11/10/37
8005 PENNSYLVANIA Circle N.E.

STANDARD REQUIREMENTS FOR DRAINAGE PLANS

GRADING &
DRAINAGE PLAN

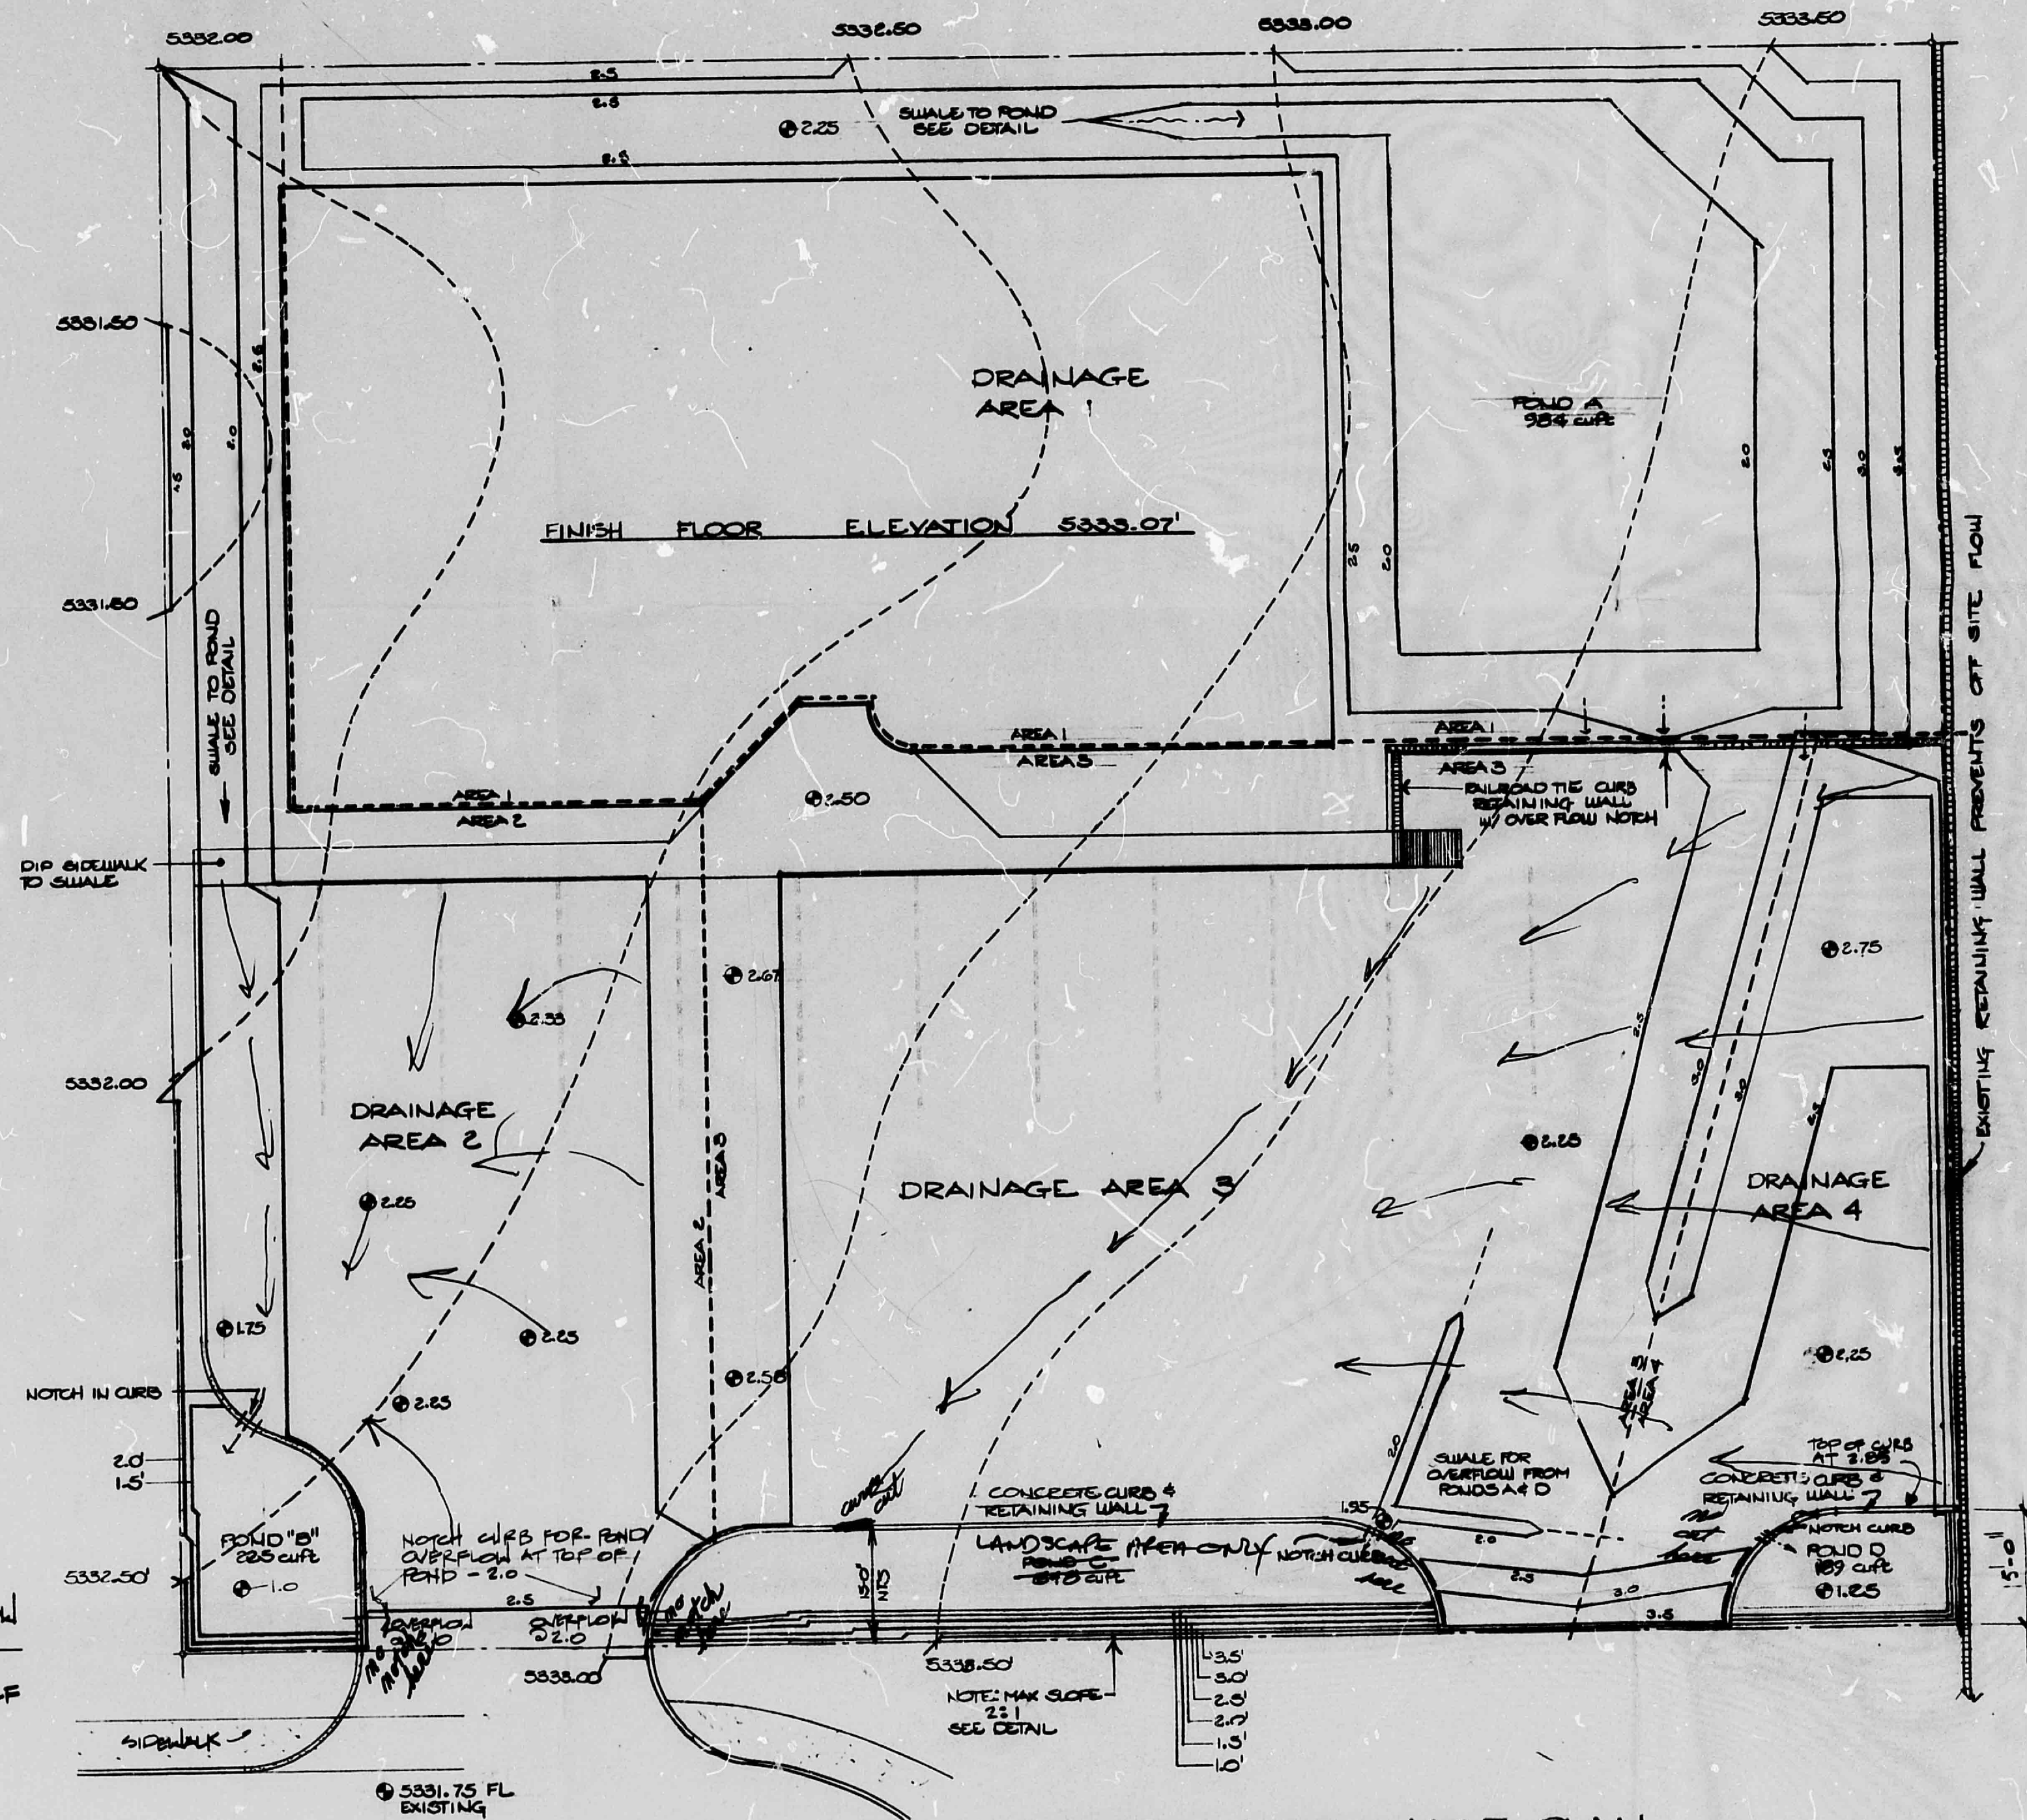
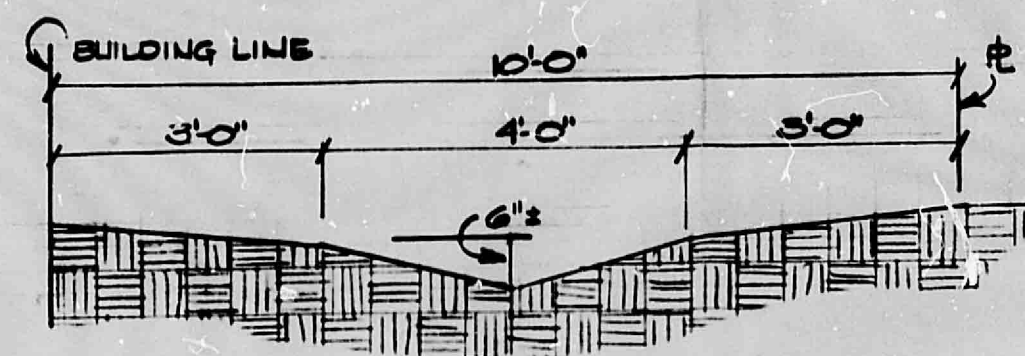
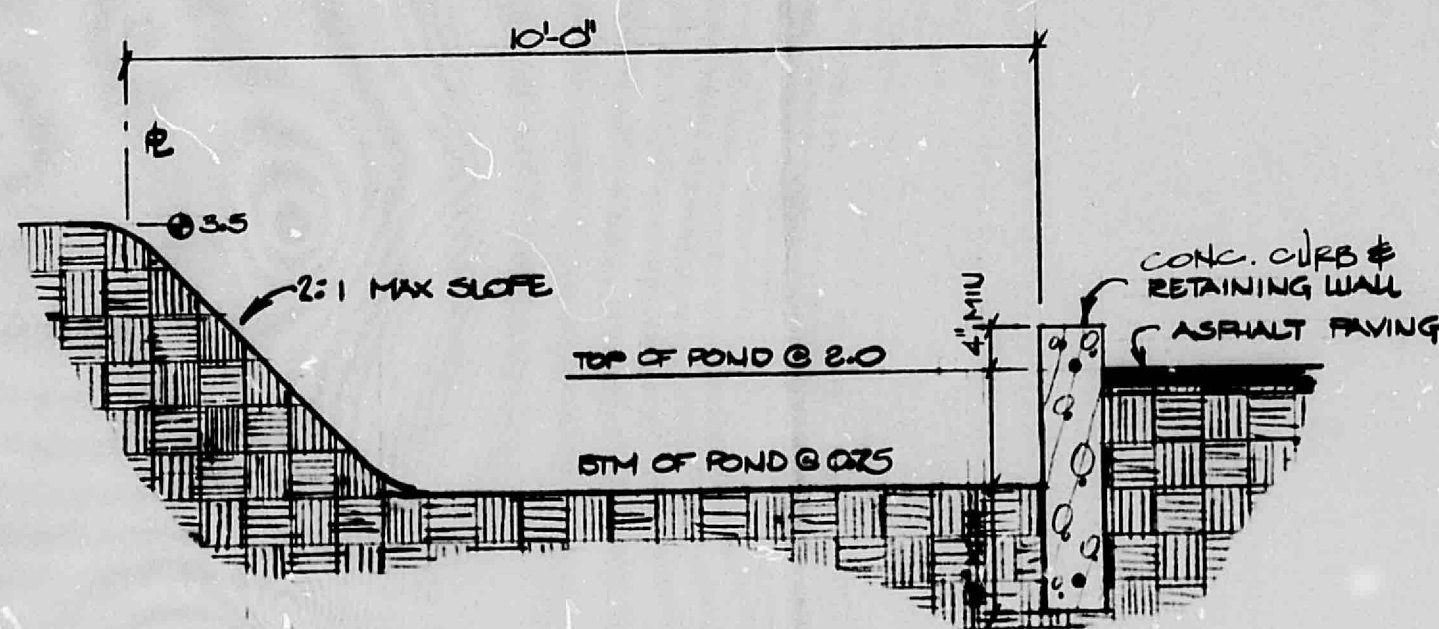
YES Per topo map, does property intercept other drainage upstream?

YES Does development block drainage from adjacent property?

NO Does site plan show proposed grading with adequate swale definition to convey water to ponds?

YES Does the proposed grading plan indicate that under cutting or back-filling adjacent to property lines may require retention walls?

? Is ponding volume adequate (supply detailed computation)?

NO Are ponds balanced with areas they drain (can area draining to each pond be easily identified and will actually water flow there)? The plot plan must outline each drainage area.

NO Can pond volume be computed and verified?
